HAREFIELD ESTATE (MIDDLETON)
MANAGEMENT LIMITED

Ref Planning Application M26/15/HH

1 West Avenue, Harefield Estate

Scale:	1:100 1:500
Date:	29th September 2013
Drawn by:	
Drawing 1 / 5

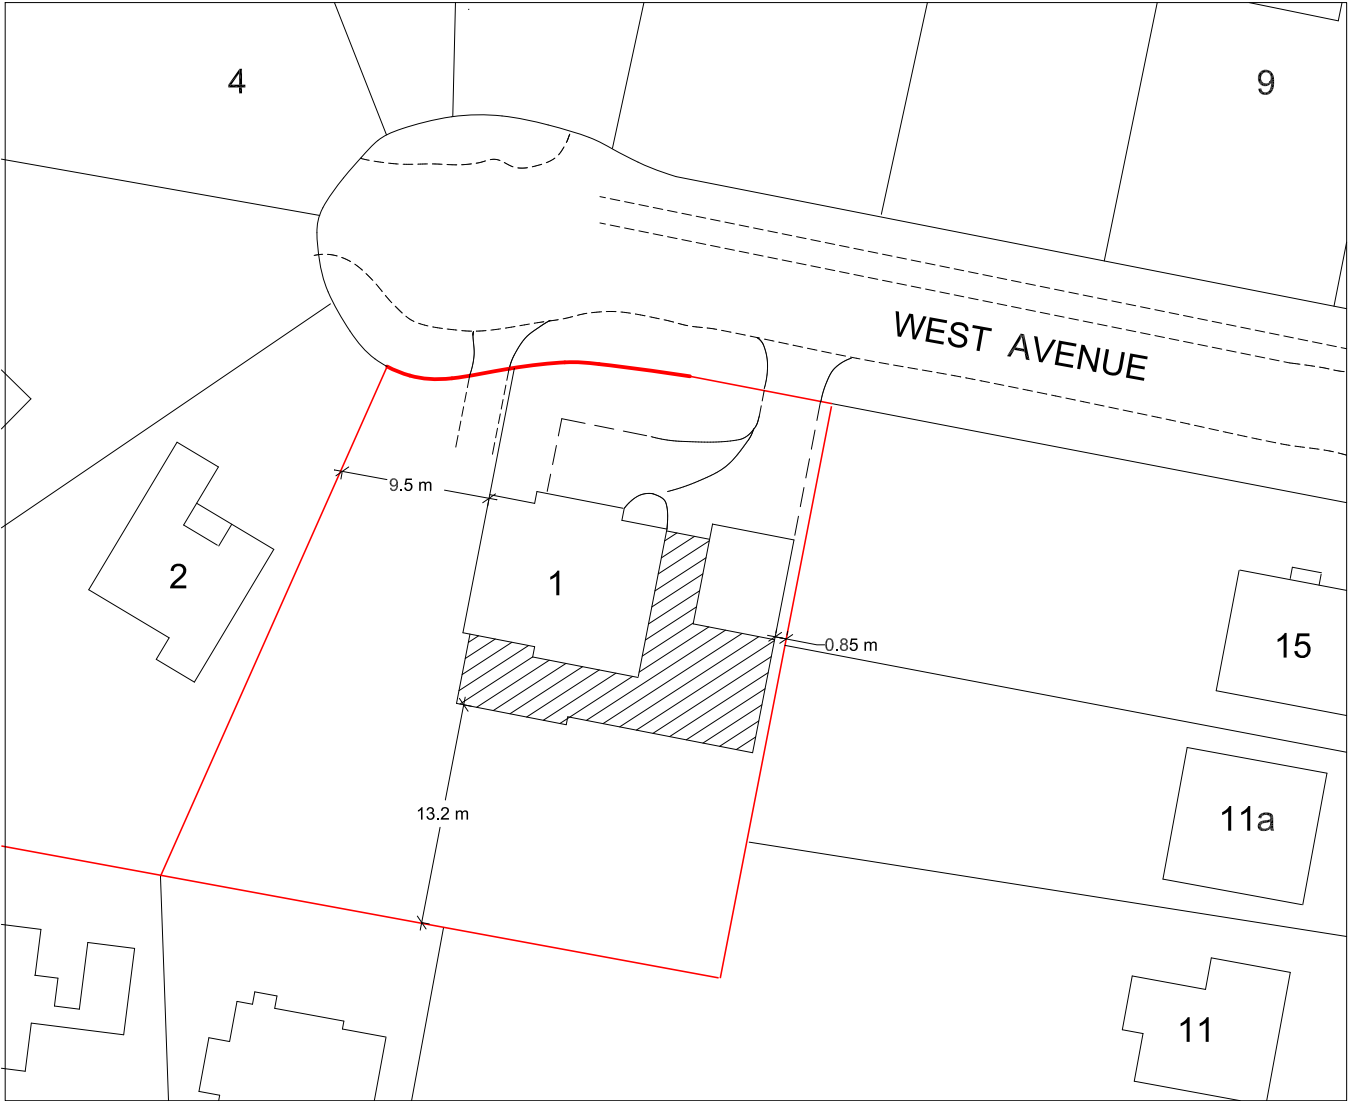
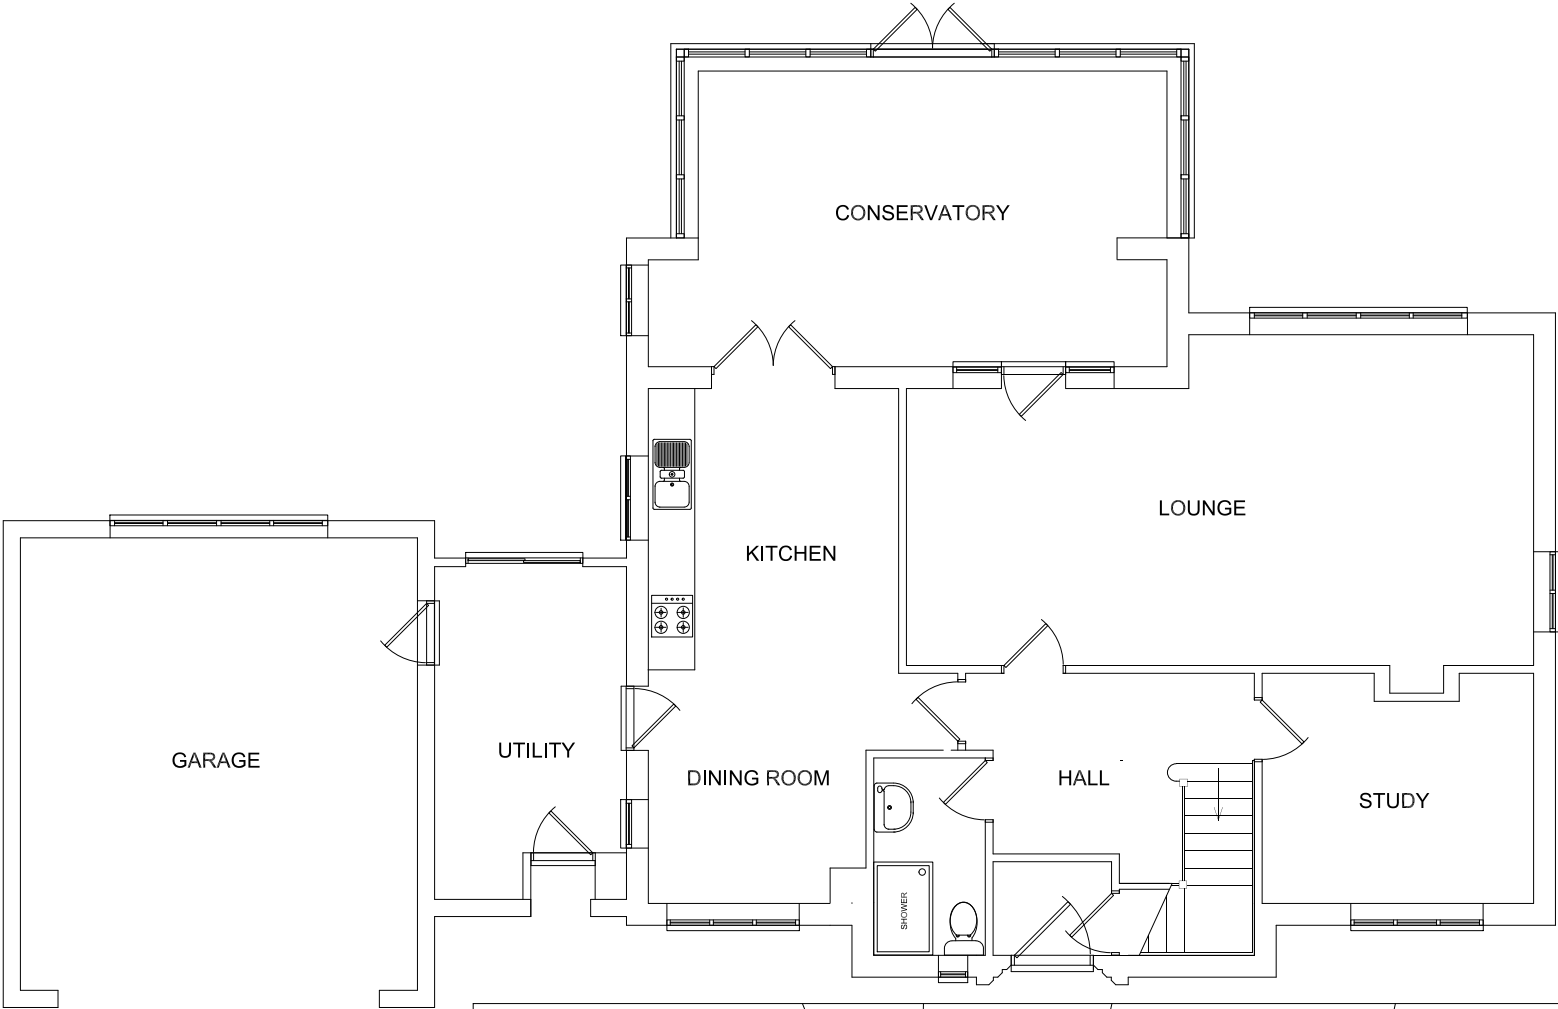
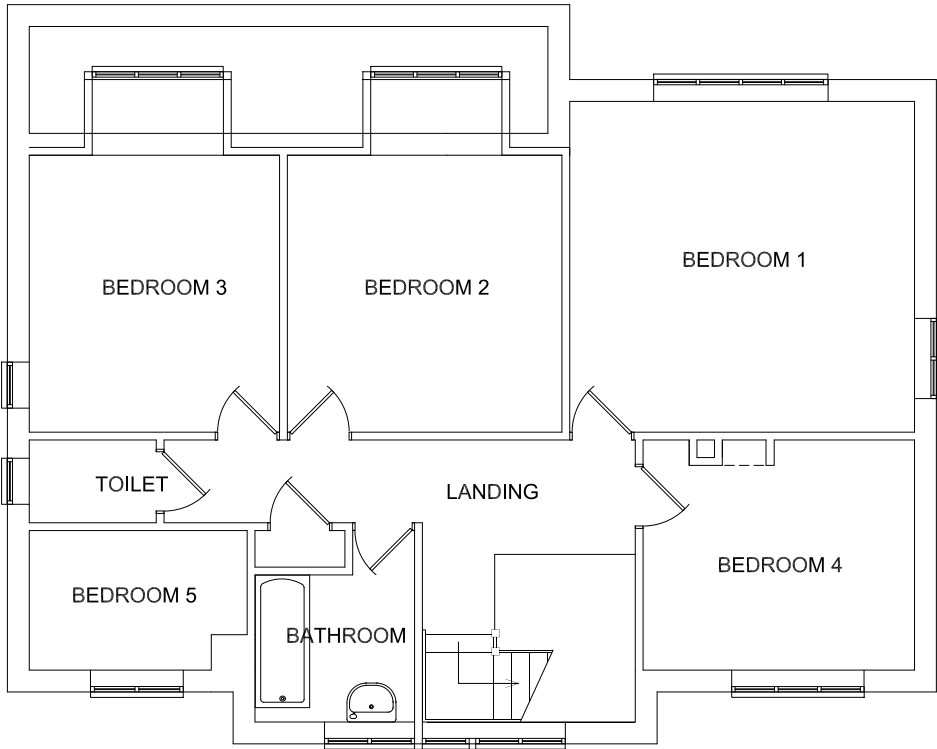
The Applicant has shown on his drawing 1/5 an access for which he knows he is not legally possible to use - under his present deeds.

Our Estate plan clearly shows that there is NO ACCESS IN THE POSITION SHOWN ON HIS DRAWING 1/5

Therefore the Applicants drawing is incorrect and misleading

There is a new vehicle access commenced from the private road shown on drawing 1/5 which is not legal.
